RE: Garcia Apartments
Grading Plan
Stamp Date: 6/29/17
Hydrology File: K20D063

Based upon the information provided in your submittal received 7/1/17, the Grading Plan **is not** approved for Building Permit. The following comments need to be addressed for approval of the above referenced project:

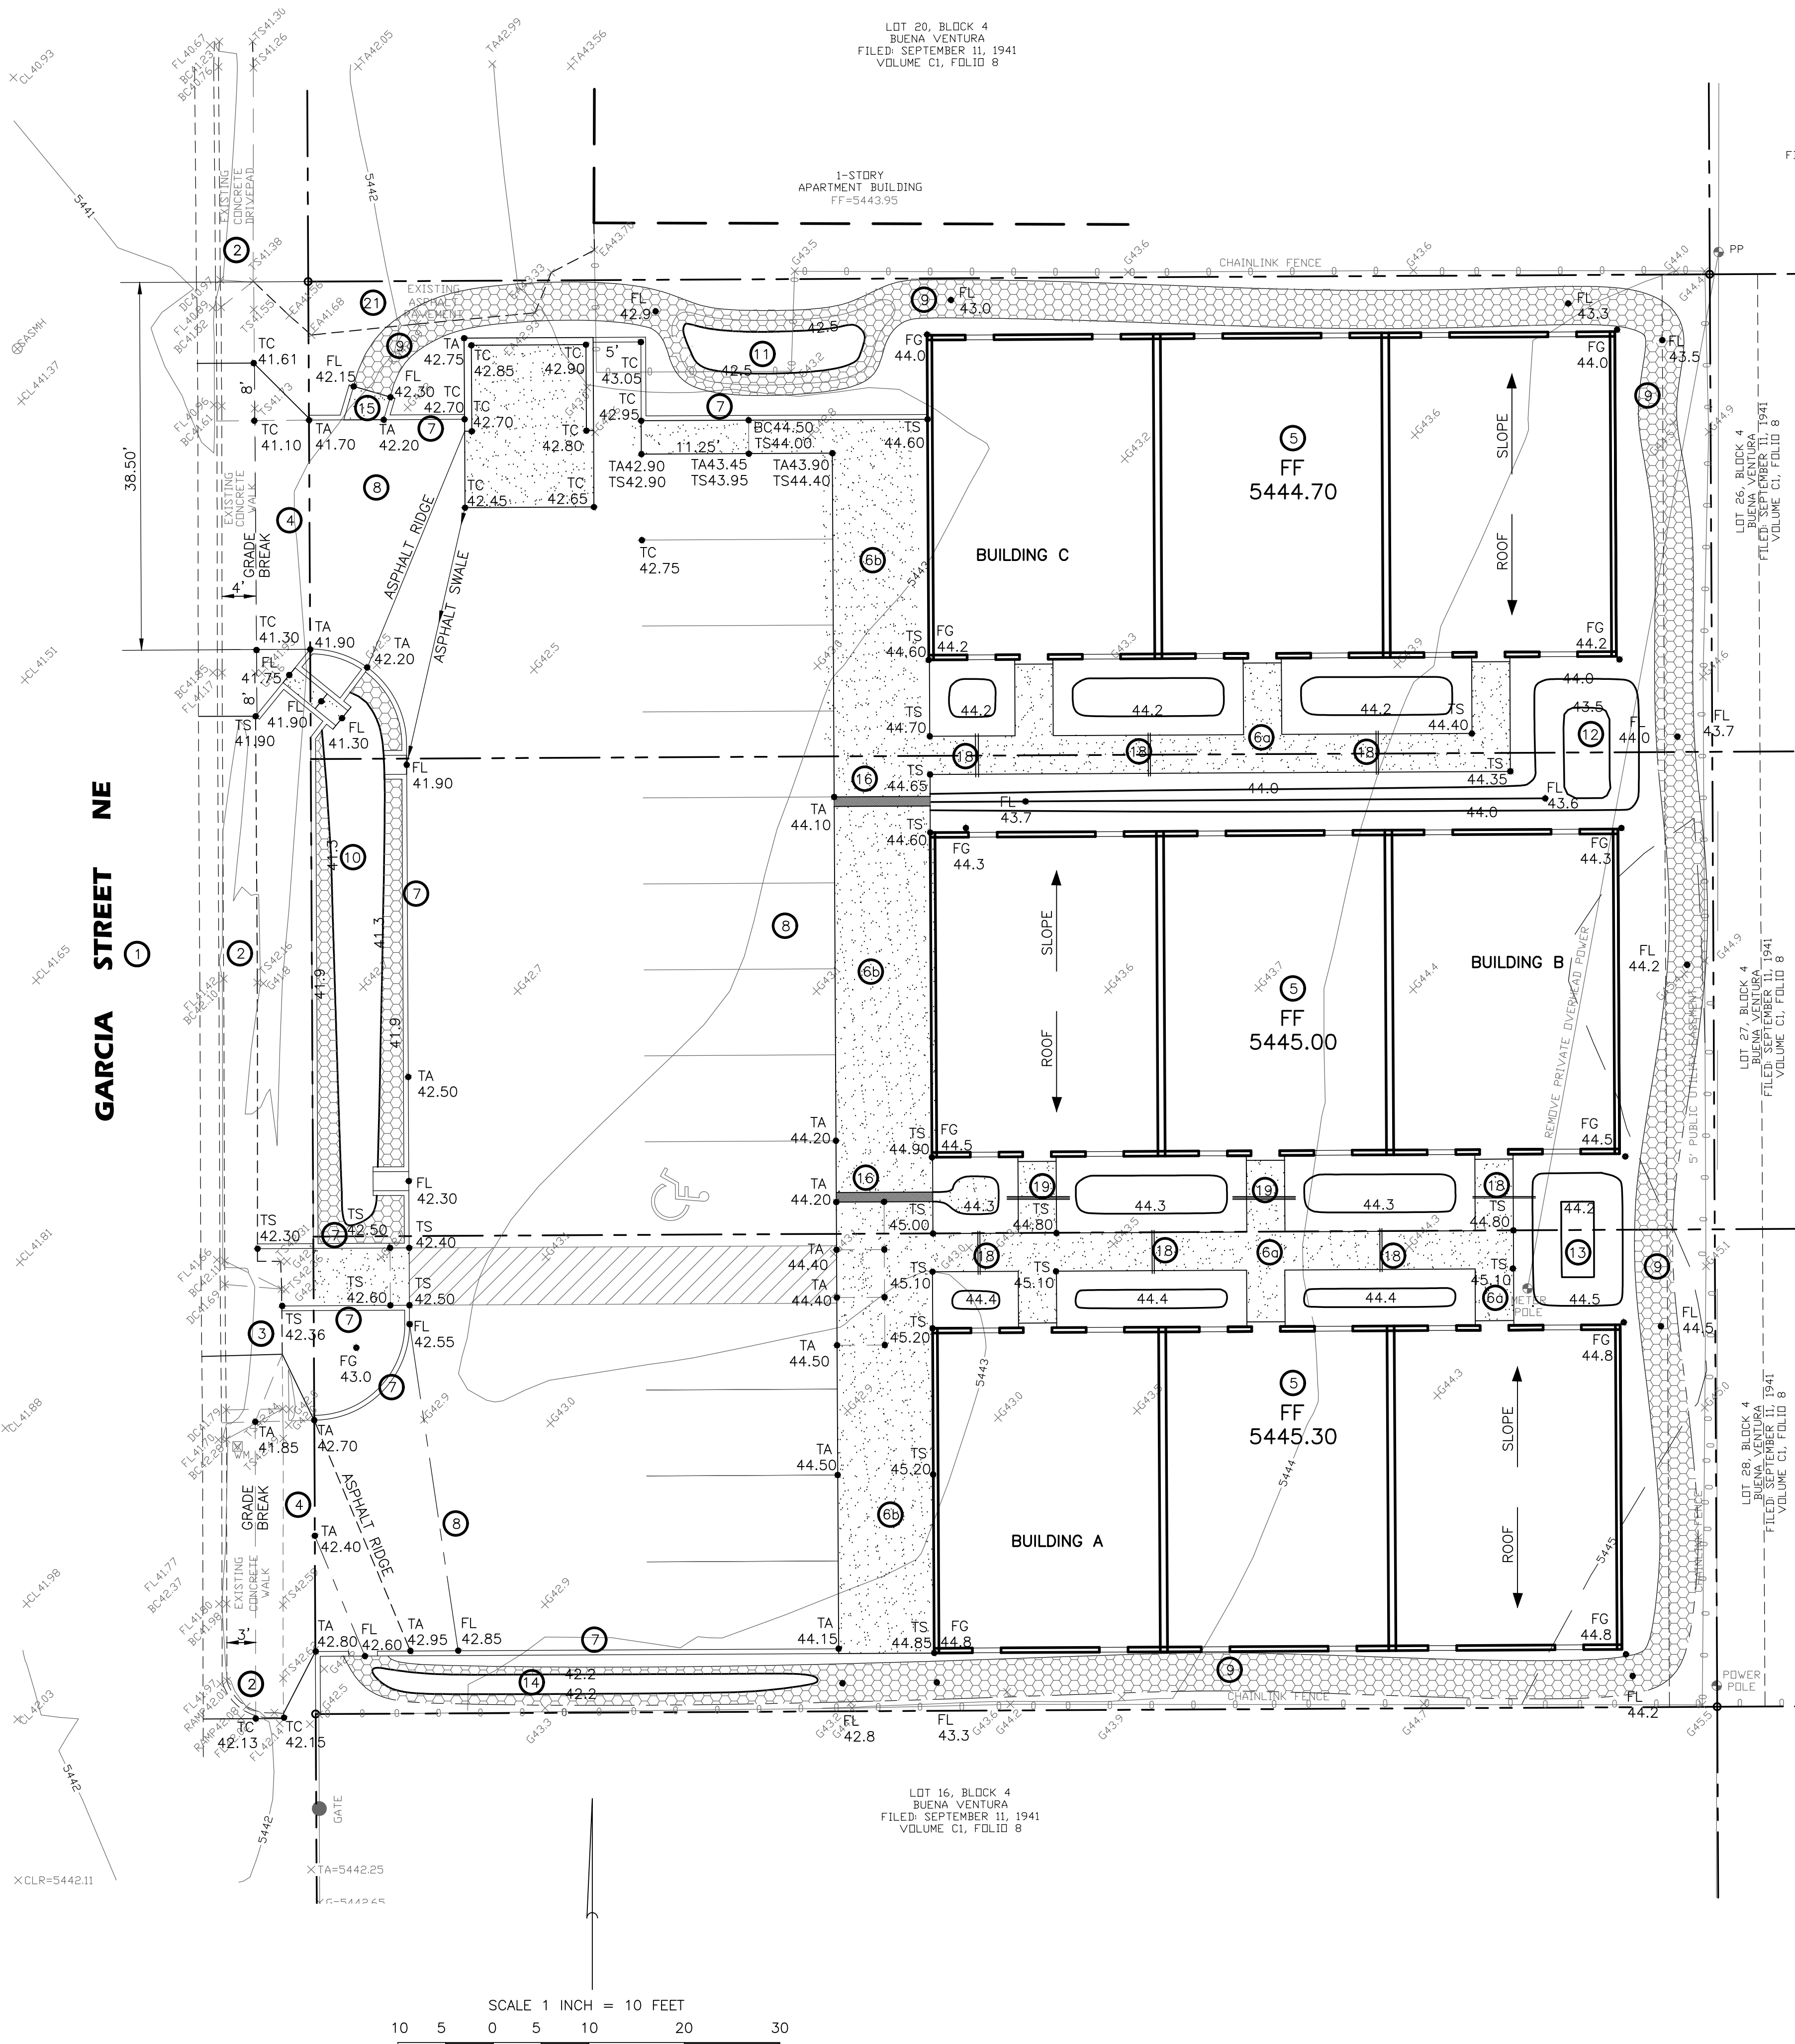
1. On Sheet C1.1. Please turn on the FIRM map.
2. On Sheet C1.11. In Keyed Notes #16 & 17, there is a "X" wide concrete channel" called out. Please the width of these two concrete channels.
3. On Sheet C1-1. Please wipeout the hatch at each Keyed Note's circle so the number can be read.
4. On Sheet C1-2. Please add the proposed volume column in the Water Harvesting chart so the proposed volumes for each pond are shown.
5. On Sheet C1-2. For the Drainage Data, please add drainage arrows. This will help show how the individual basins will leave the site. Also does any of the offsite drainage come onto the site? It is unclear if it does or not, however you do show the offsite area.
6. On Sheet C1-2. Please provide drainage calculations for both the existing and the proposed 100 year – 6 hour storm event.
7. On Sheet C1-2. Please provide the weir calculations for the curb cuts.
